Subject: Re: EP/16/21/PL

Client: Mr D Lynch		
Project Address: The Garage The Way East Preston		
Drawing Title: Existing and Proposed Plans and Elevations		
Drawing Number: 1241.01.g		
Scale:	As stated printed @ A1	
Date:	06/01/2020

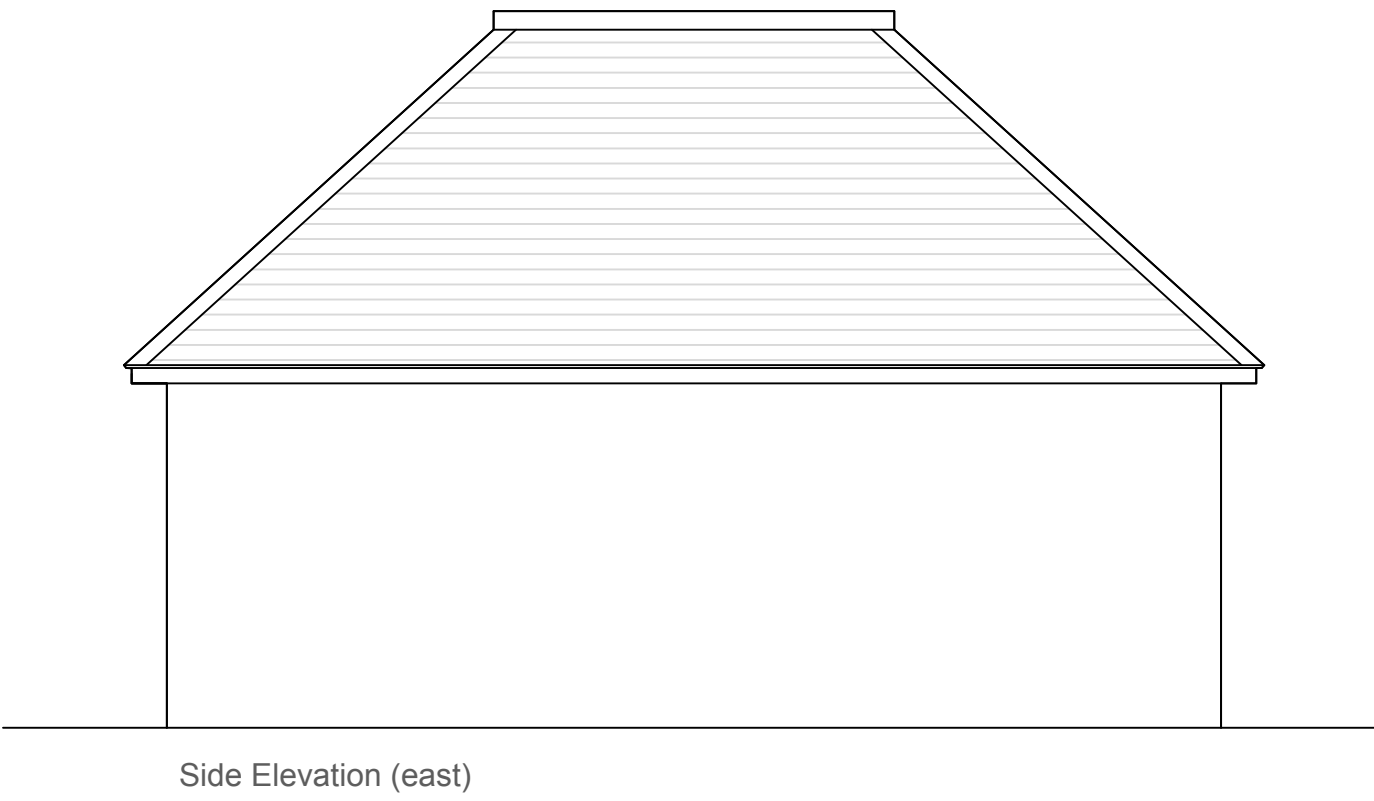
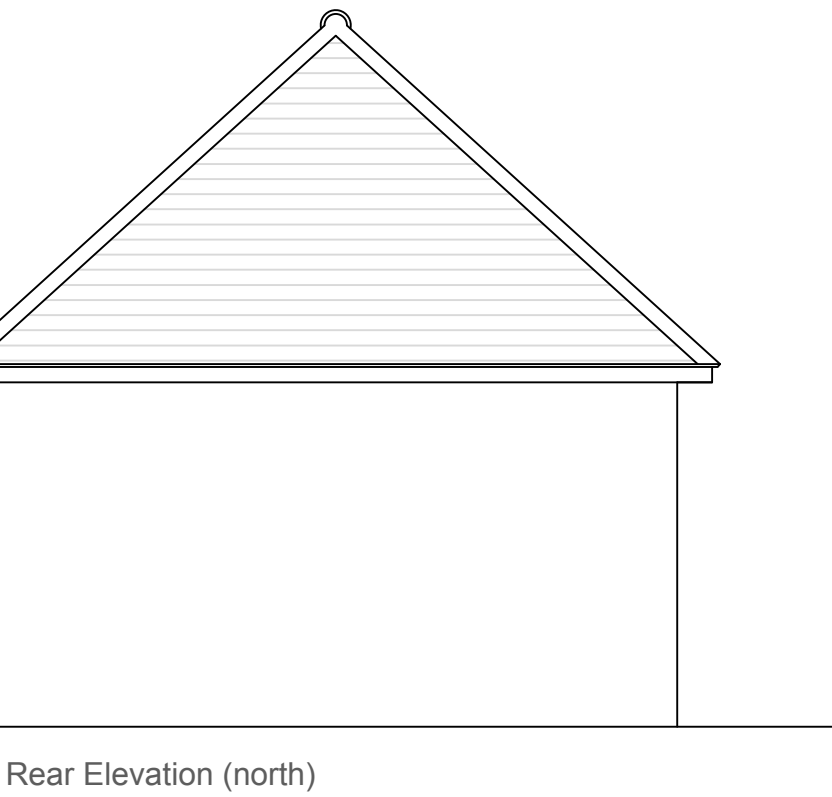
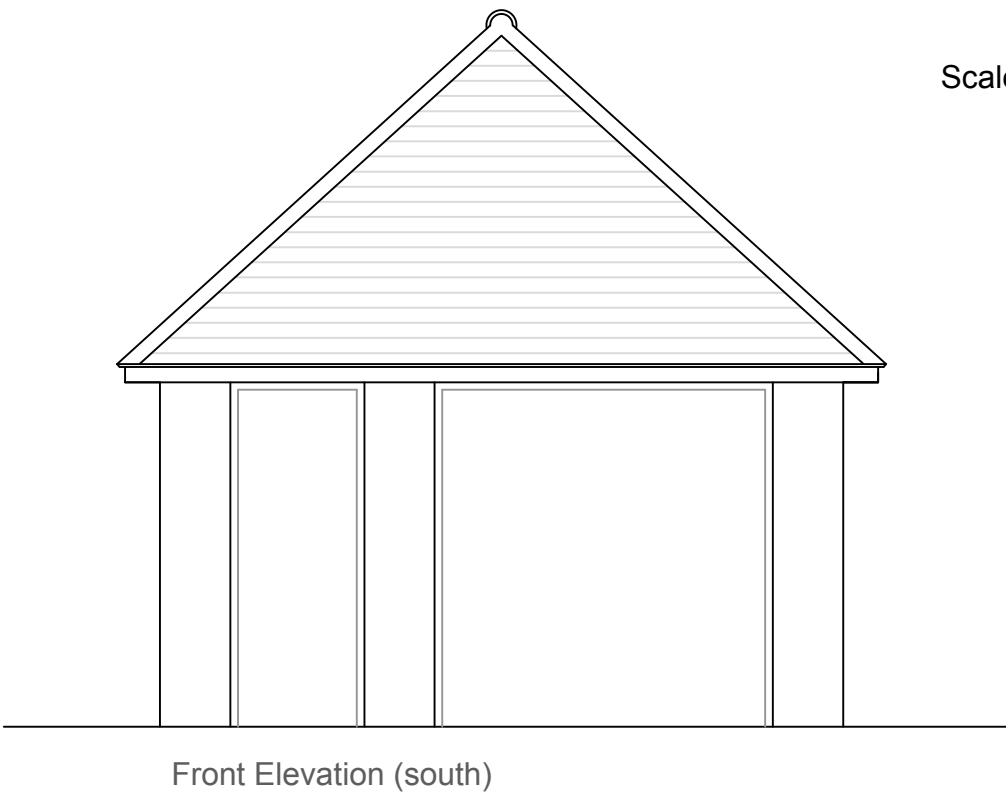
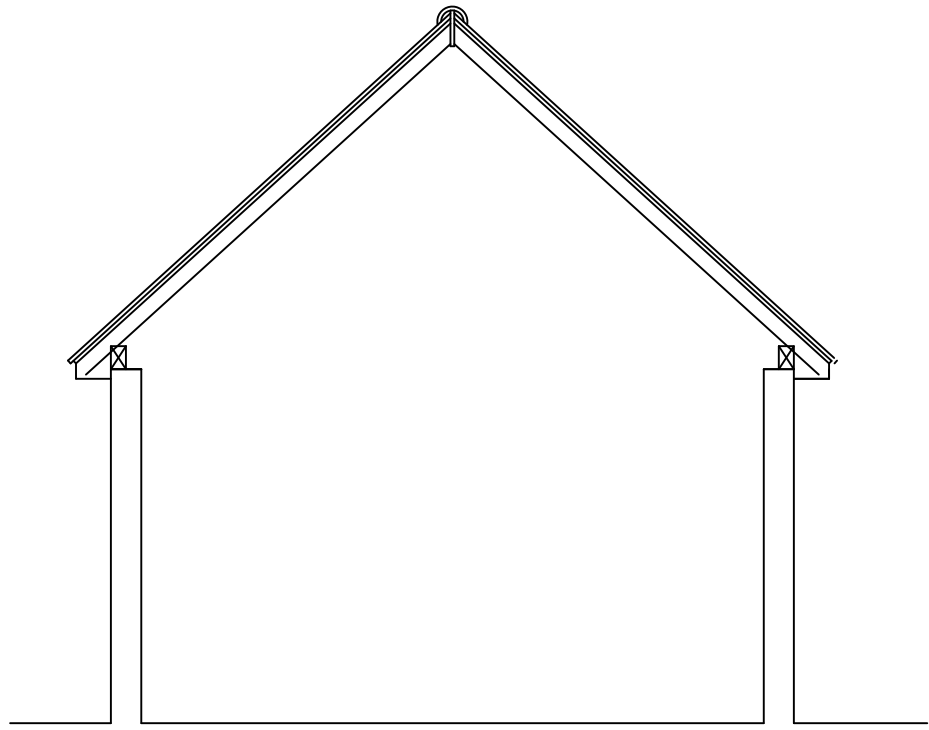
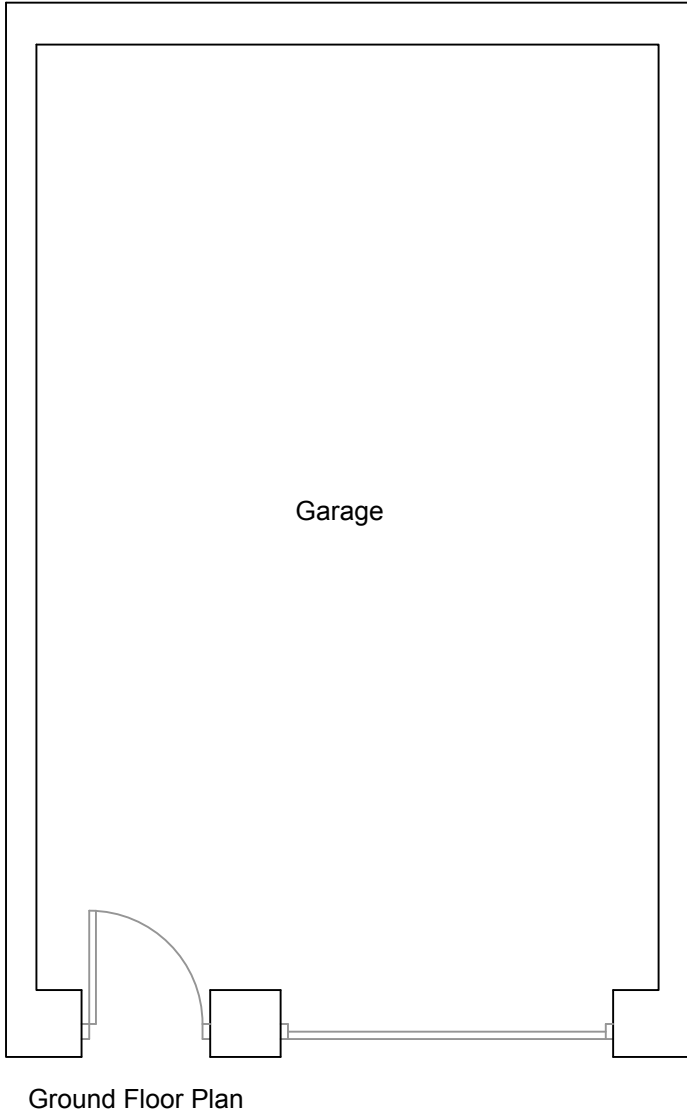
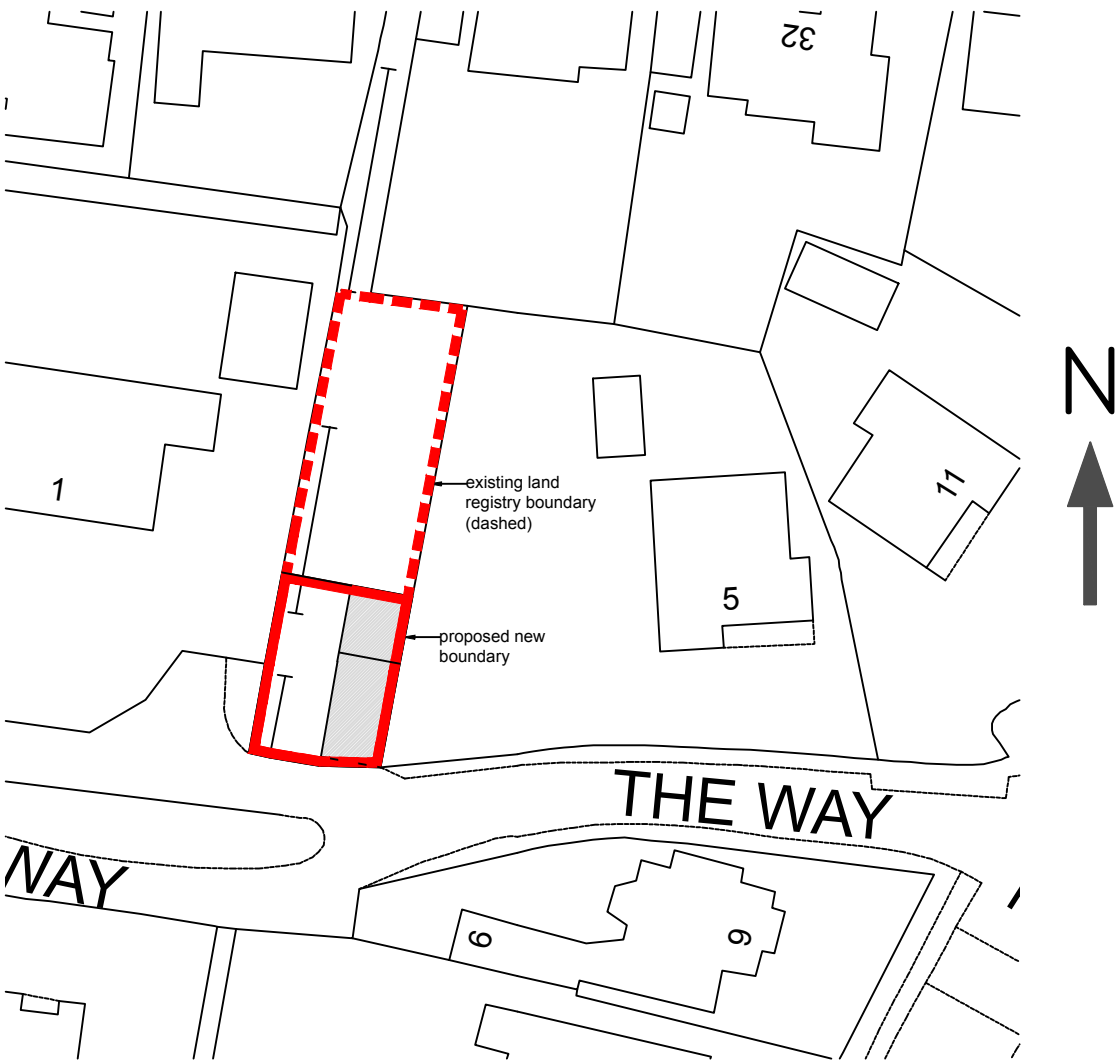
There has been a condition added to this application to show the three windows on the side (east) elevation of the garage will be permanently obscurely glazed and fixed shut up to a height of 1.7m from the finished floor level in order to protect the private amenity to the neighbours at the east. Please can you provide a plan to show this with a cross section from the ground to 1.7m to show the windows will be obscurely glazed and fixed shut up to a height of 1.7m.

There has also been concerns of why a dormer would be necessary for a garage if it is to be used as storage. As a result, it would be necessary to remove the dormer to the garage for this proposal. Please provide amended plans to show the dormer has been removed.

The three windows on west elevation should also be removed from the proposal as the garage will be used for storage there is no necessary need for windows, this will also create amenity issues.

1. An amended plan for the east elevation to show the cross section from the ground to 1.7m to show the windows will be obscurely glazed and fixed shut up to a height

I have removed the dormer and reduced the number of roof lights. I have also reduced the size of the roof lights and positioned them so the cill of the roof lights are 1.7m from finished floor level so there is no overlooking. I have included a section to demonstrate the position of the roof lights.

I have reverted to a hipped roof at the rear of the building which is as per the pre-application advice scheme. I have done this in order to accommodate the staircase and still provide space for the two cars in the garage.
